Project Name: * R-5014-Widening of SR1217 from dead end to US158

Subject: **Request for Minor Modification of the CAMA Major Development Permit** for the widening of SR 1217 (Colington Road) from Dead End to US 158 (Croatan Highway) in Dare County, North Carolina; TIP Project R-5014, Federal Aid Project No. STP-1217(6); Debit \$100 from WBS Element 41162.1.1

Reference: CAMA Major Development Permit #125-18 issued November 5, 2018

The NCDOT is requesting a Minor Modification for CAMA Major Development Permit #125-18.

**CLEARING AND GRUBBING  
EROSION CONTROL FOR  
CONSTRUCTION SHEET 07**

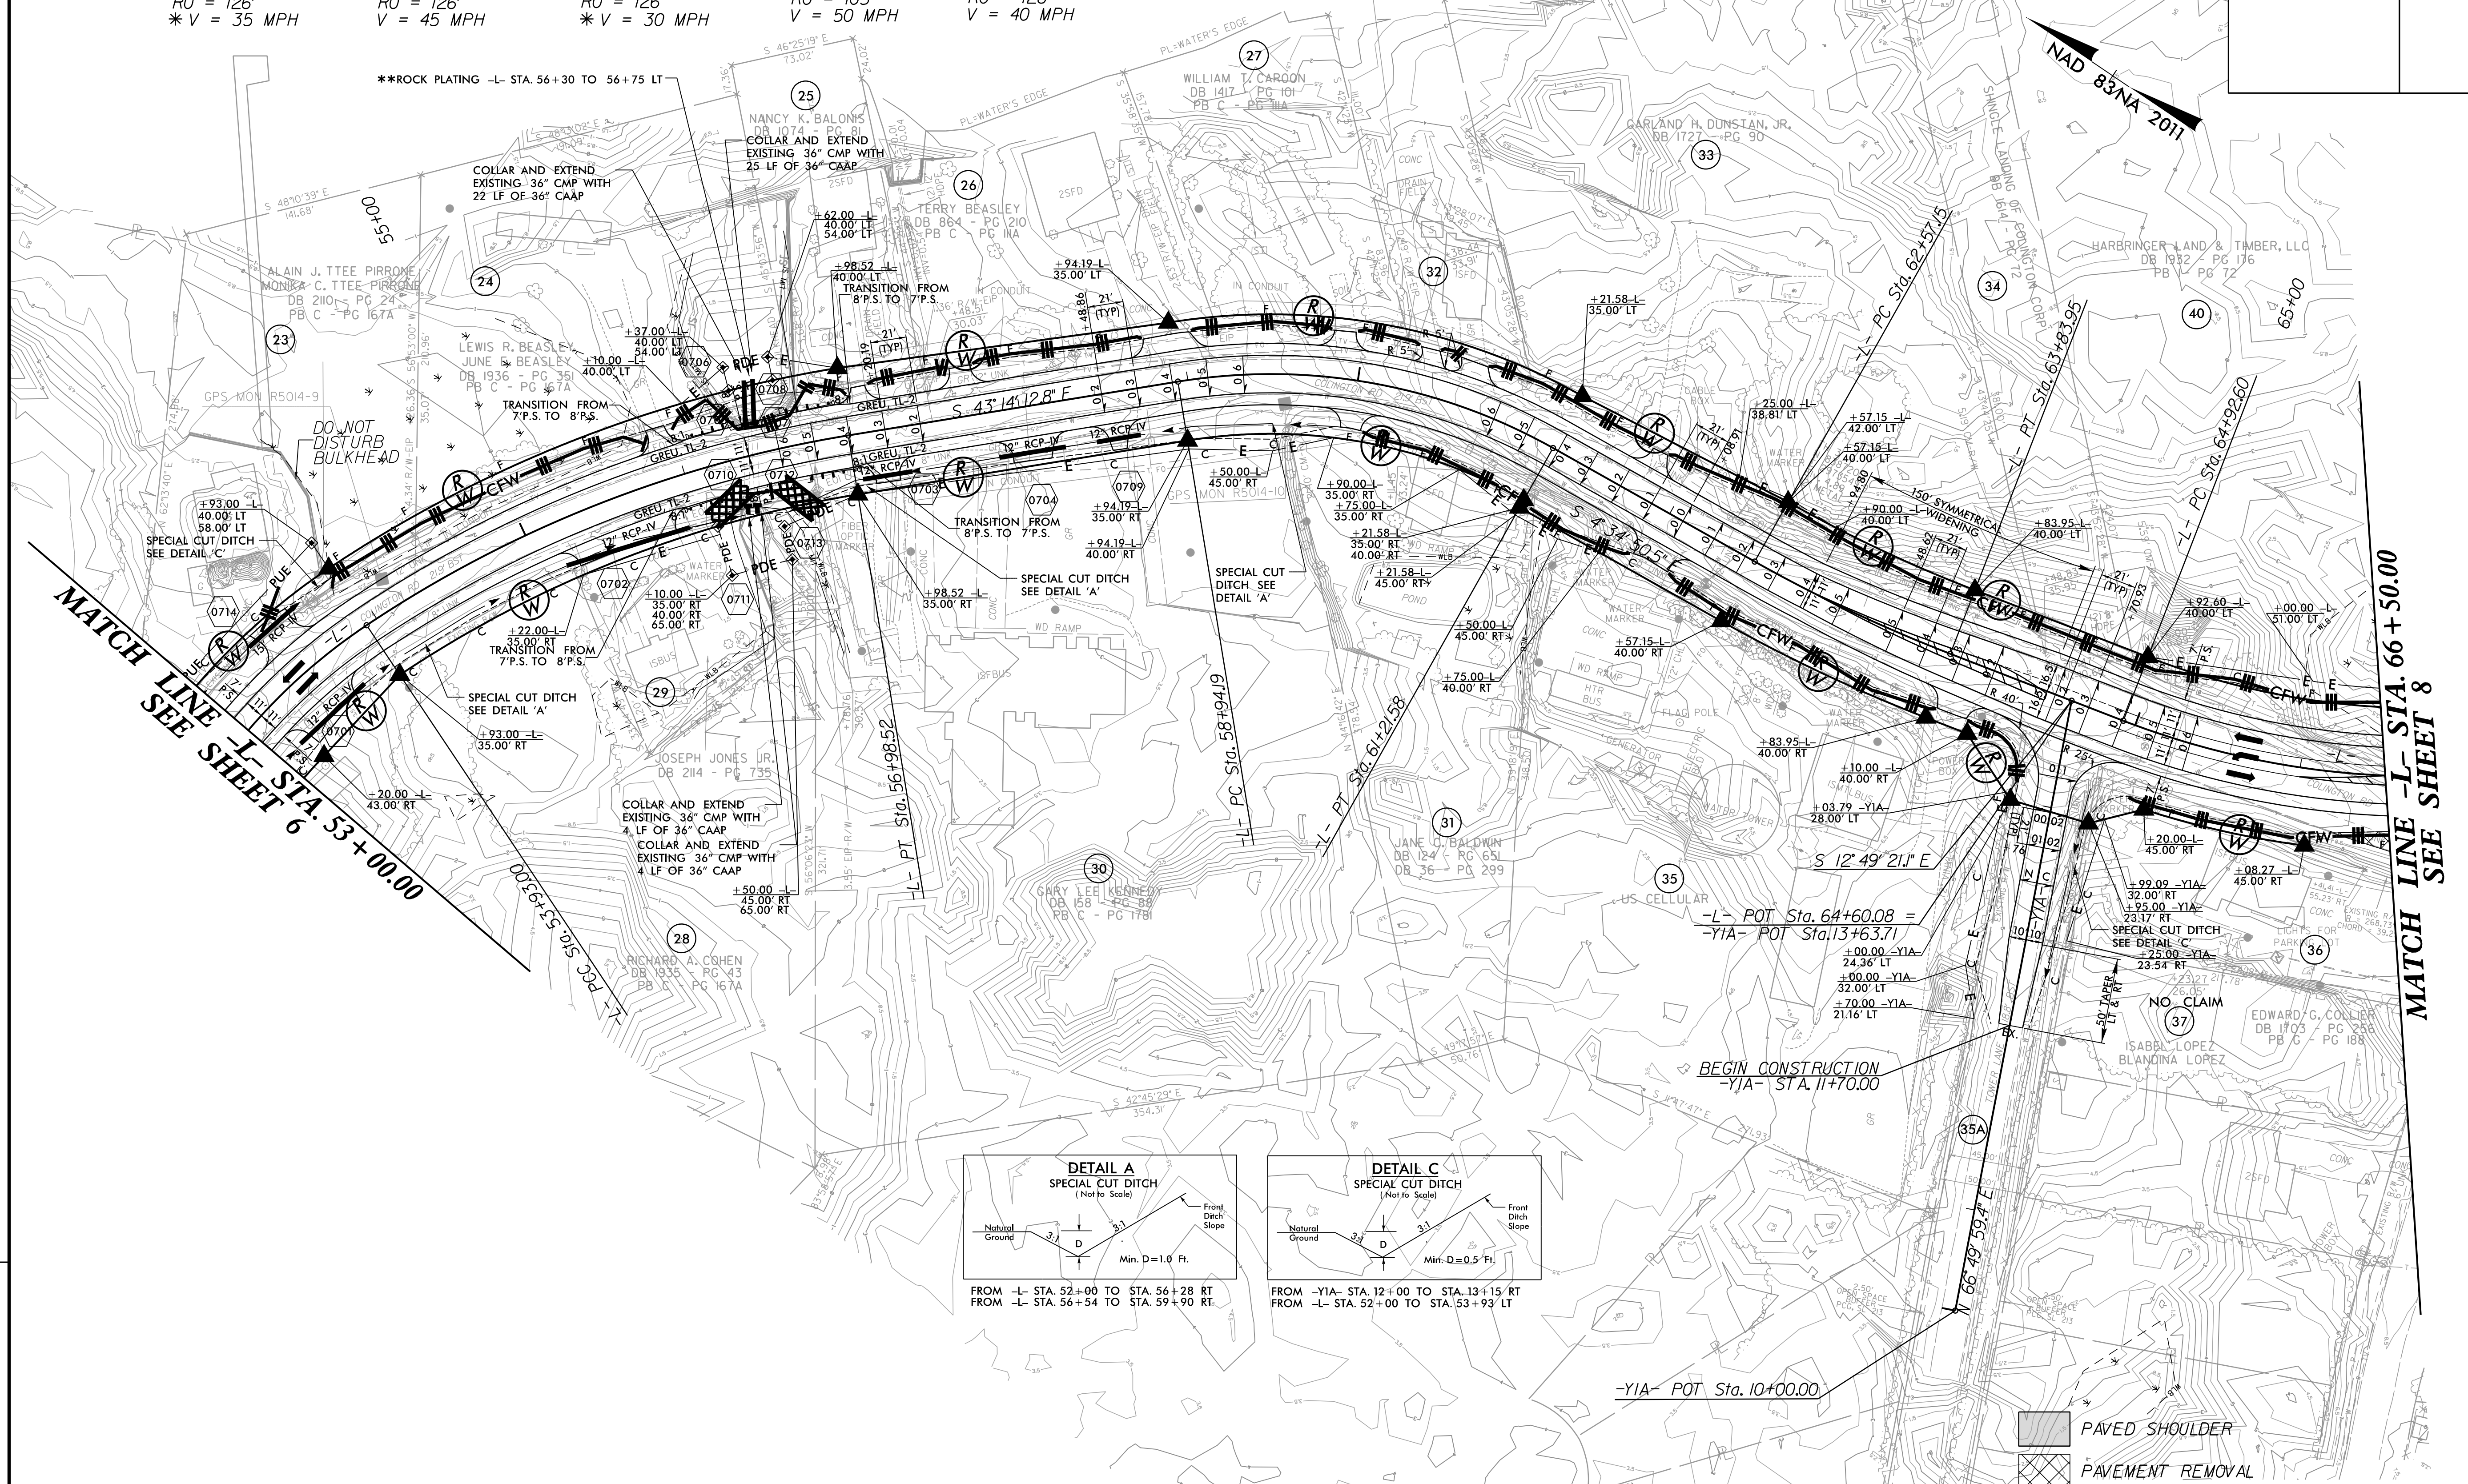
- Site 2** 56+30 to 56+75 LT, rock embankment / rock plating
SW fill reduced to <0.01. Perm. channel impact increased to 32 lf.
- Site 9** 104+10 to 104+65 LT, rock embankment / rock plating
SW fill reduced to 0.01 ac., Permanent channel impact added totaling 78 lf (55 lf stabilization).
- Site 12** 126+70 to 127+55 LT, rock embankment / rock plating
SW fill increased slightly an additional <0.01 ac., Permanent channel impact added 71 lf (all stabilization).

Drawing file: 100 Roadway Plans / 100_102_R5014_RDY_FP_10.pdf

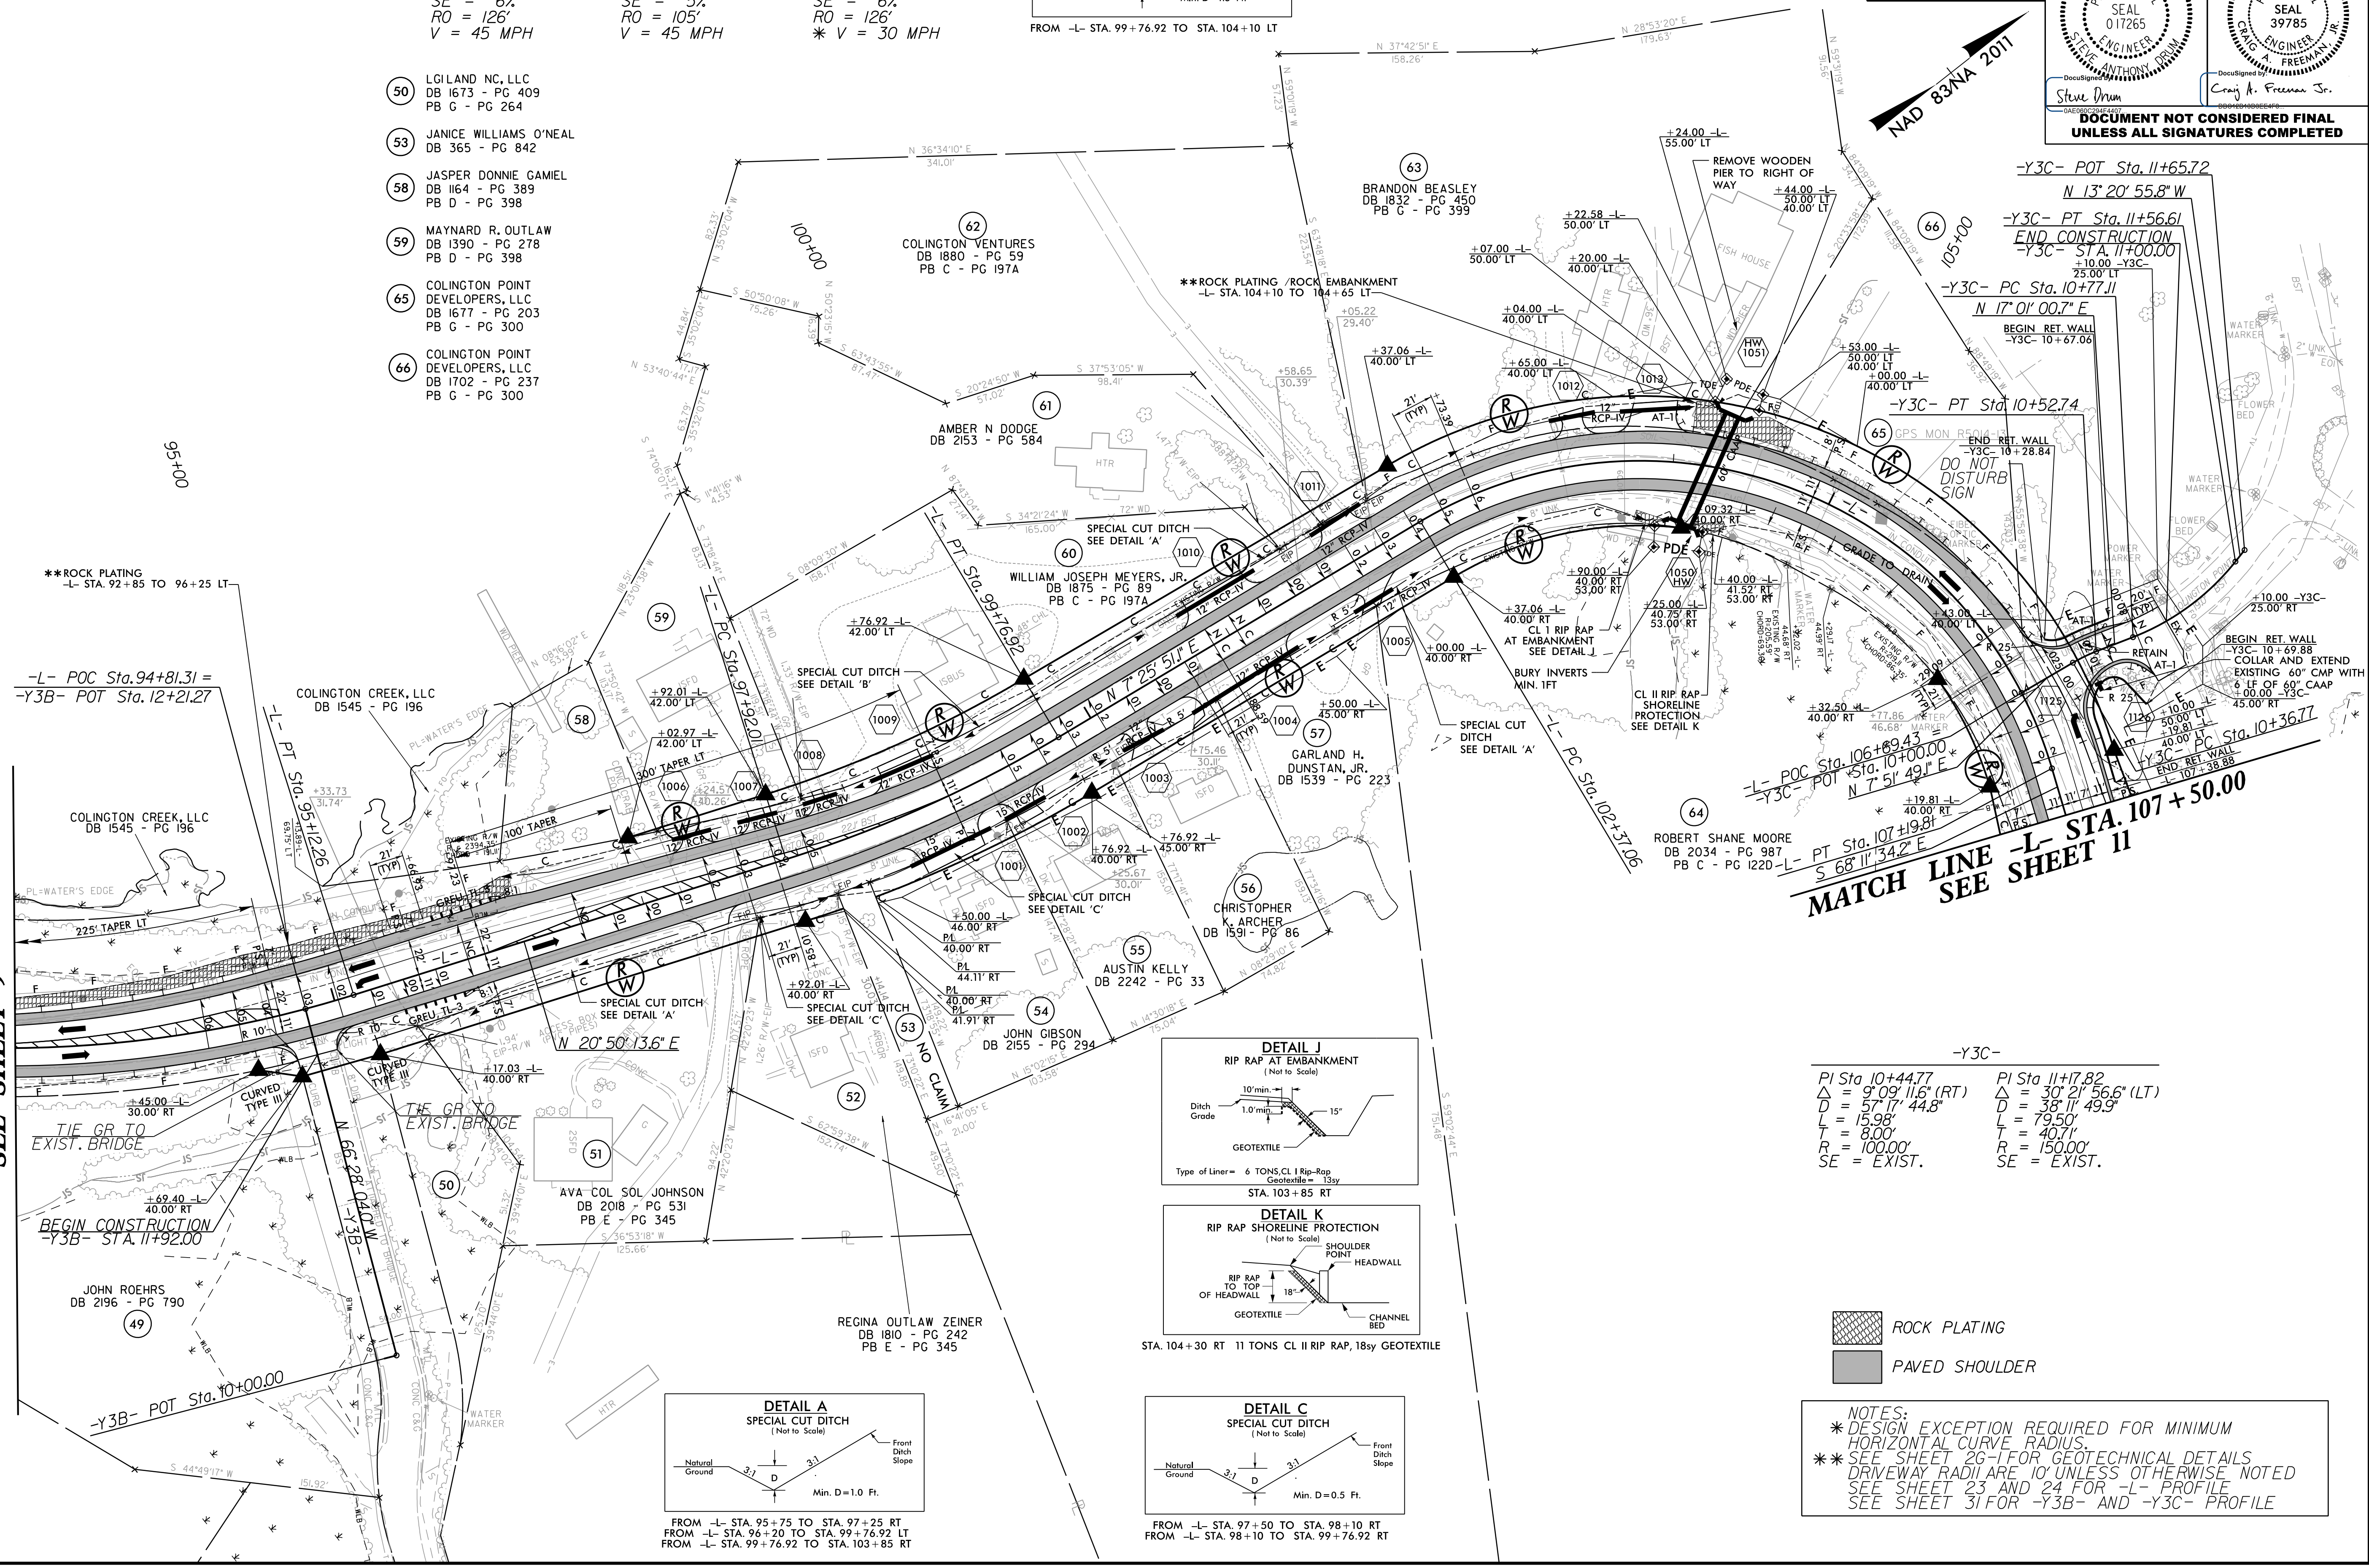
Site 8 92+85 to 96+25 LT, rock plating
